EL PASO COUNTY

COMMUNITY SERVICES DEPARTMENT

Subject: The Retreat at Timber Ridge PUD Development Plan, Review #3 (PUD-17-003)

The Retreat at Timber Ridge PUD Development Plan Review

2
OF 4

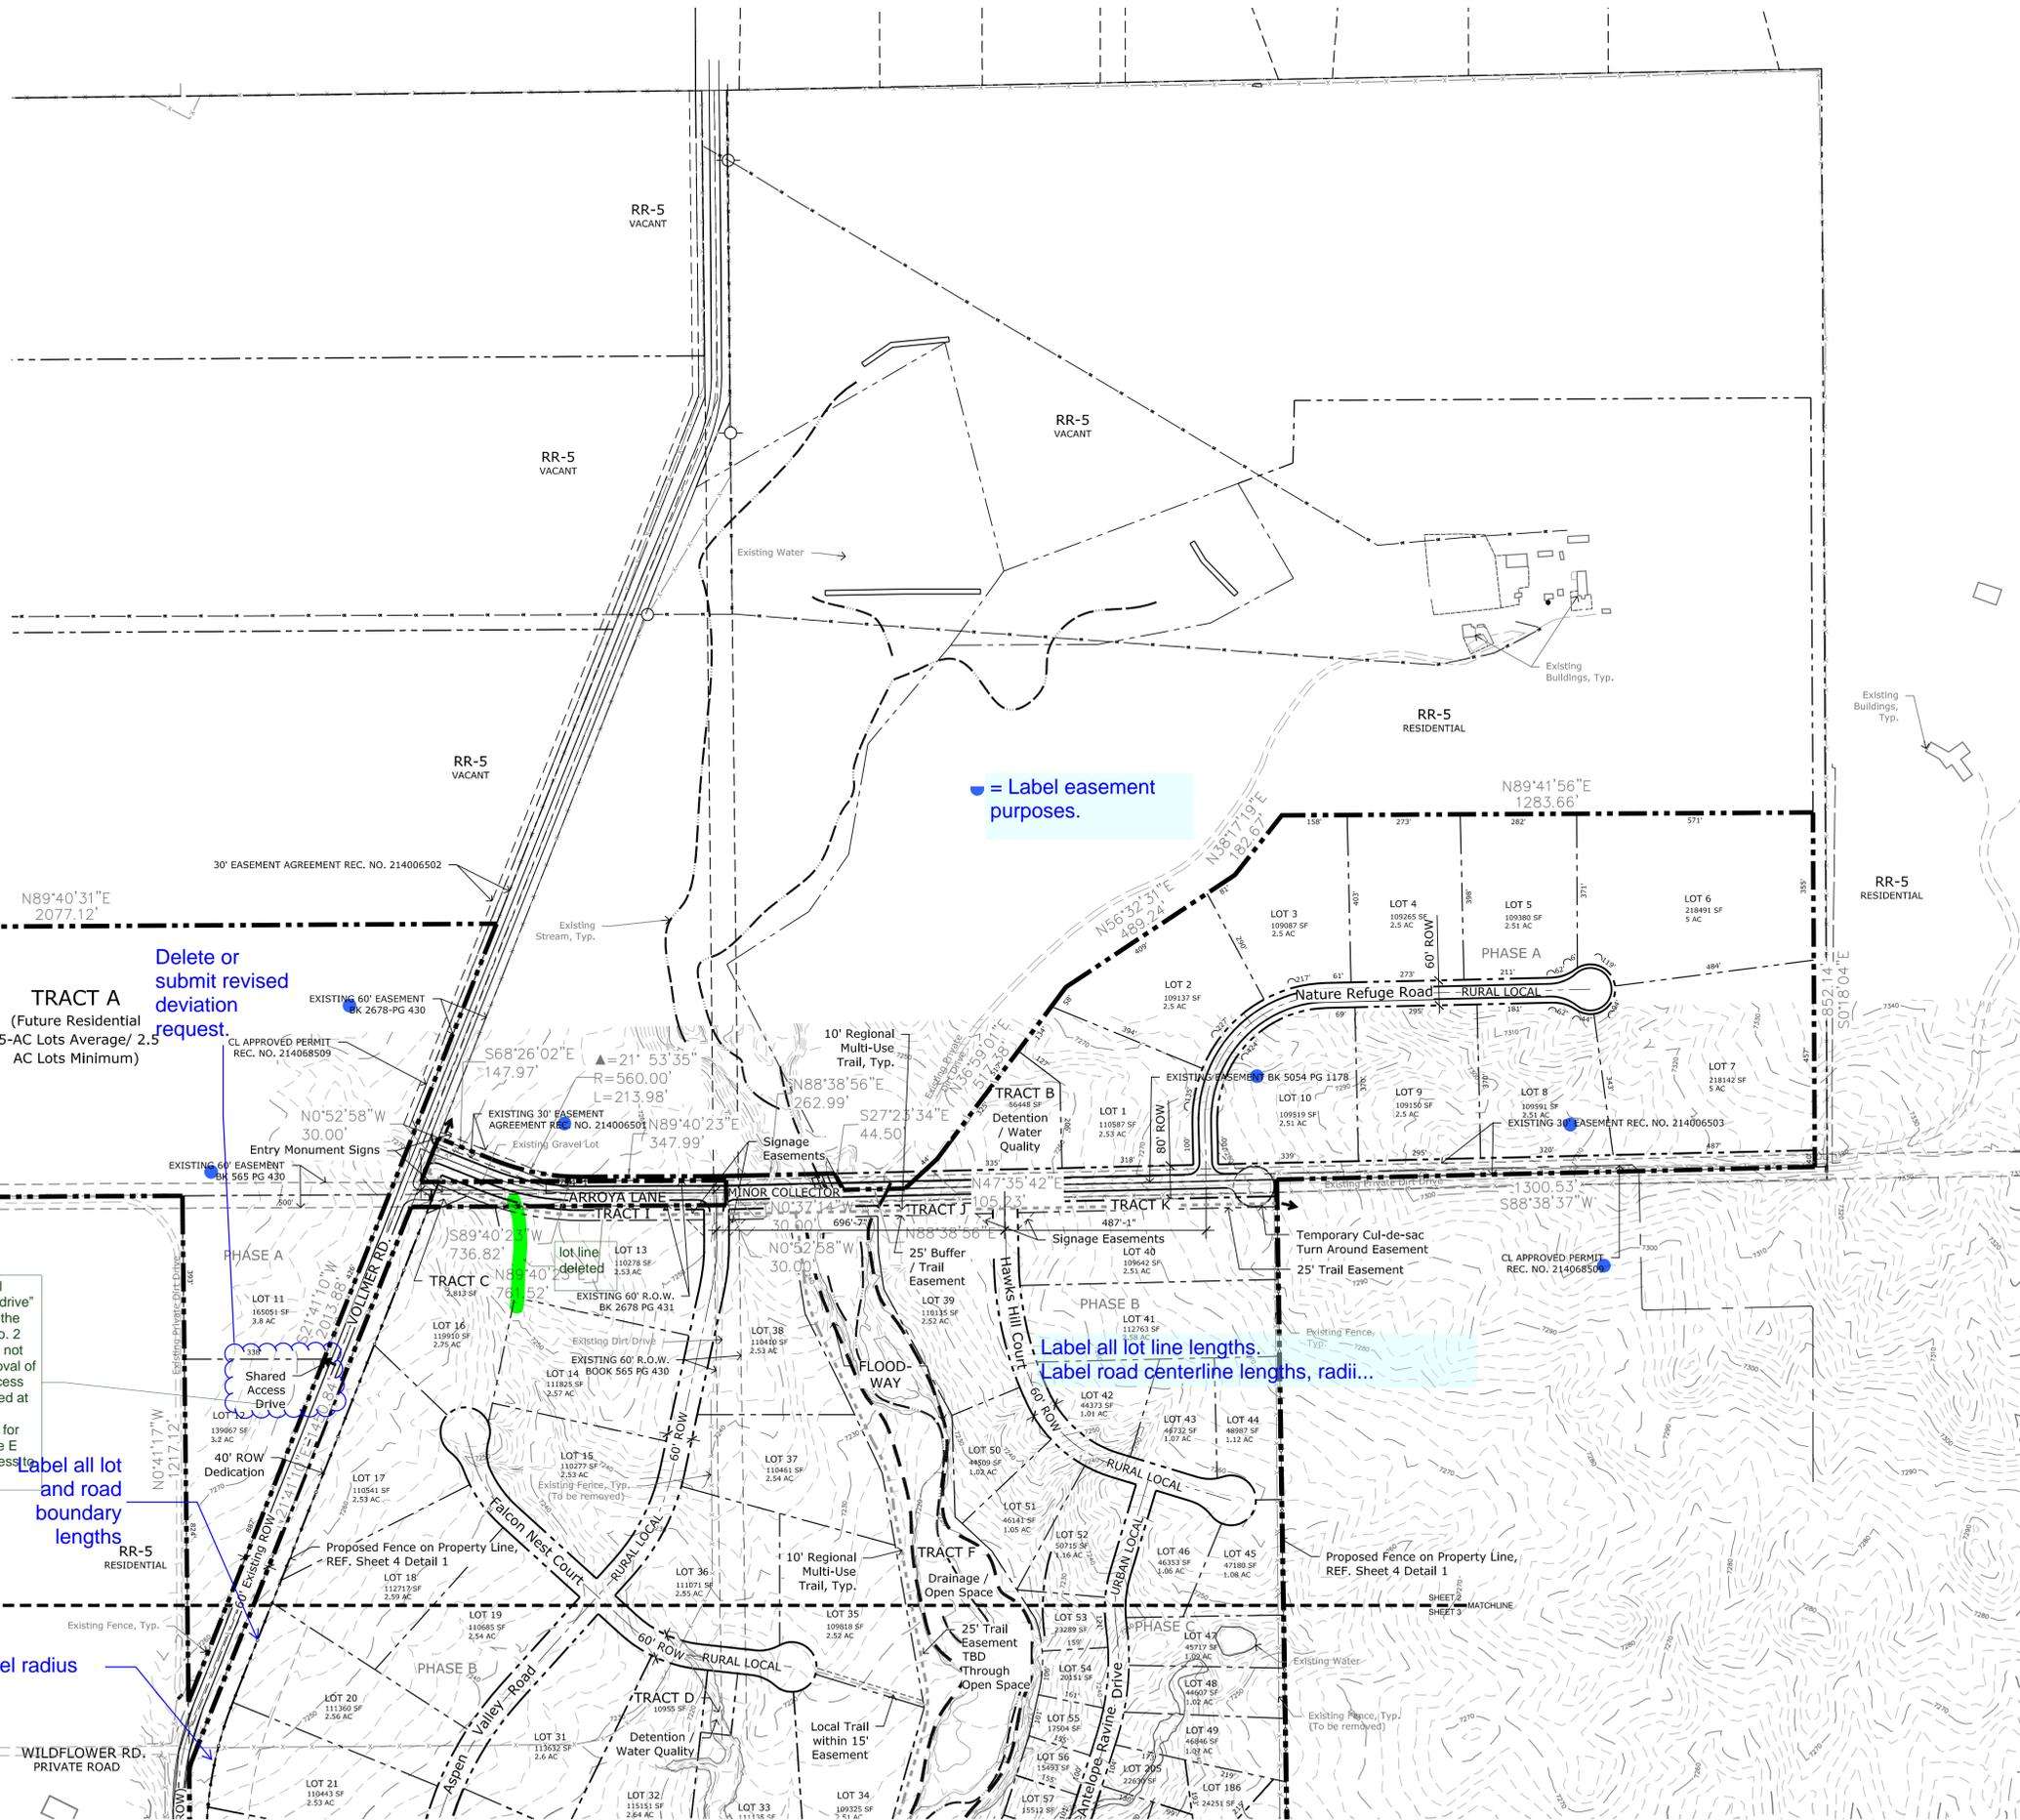
The PUD Development Plan shows 25-foot trail buffers along Sand Creek and Arroyo Lane. Parks staff recommends that all forthcoming preliminary plans and final plats show 25-foot trail easements along the Sand Creek drainage, as well as the 25-foot trail easement along Arroyo Lane, and shall dedicate these 25-foot wide regional trail easements to the County for the County’s construction and

maintenance of public multi-use trails on forthcoming final plats. Staff also recommends that the developer reestablish the neighborhood park in order to not only meet the recreational needs of residents, but also to increase the open space acreage to approximately 10%, thus meeting the PUD Development Plan open space requirement as dictated in the El Paso County Land Development Code. The applicant could apply for an Urban Park Grant to help facilitate the construction of the neighborhood park.

“Recommend to the Planning Commission and Board of County Commissioners that approval of the Retreat at TimberRidge PUD Rezone/Development Plan include the following conditions, to be implemented on all forthcoming preliminary plans and final plats: (1) provide to El Paso County 25-foot public trail easements along the Sand Creek Drainage and Arroyo Lane that allow for public access, as well as construction and maintenance by El Paso County of primary regional trails, and these easements shall be shown on forthcoming preliminary plans and final plats, and the aforementioned easements shall be dedicated to El Paso County on forthcoming final plats; (2) reestablish the neighborhood park in order to not only meet the recreational needs of residents, but also to increase the open space acreage to approximately 10%, thus meeting the PUD Development Plan open space requirement as dictated in the El Paso County Land Development Code; and (3) require fees in lieu of land dedication for regional park purposes. The amount of \$91,160 was calculated for informational purposes and is based upon the preliminary lot layout and will be adjusted as preliminary plans and final plats are submitted.”
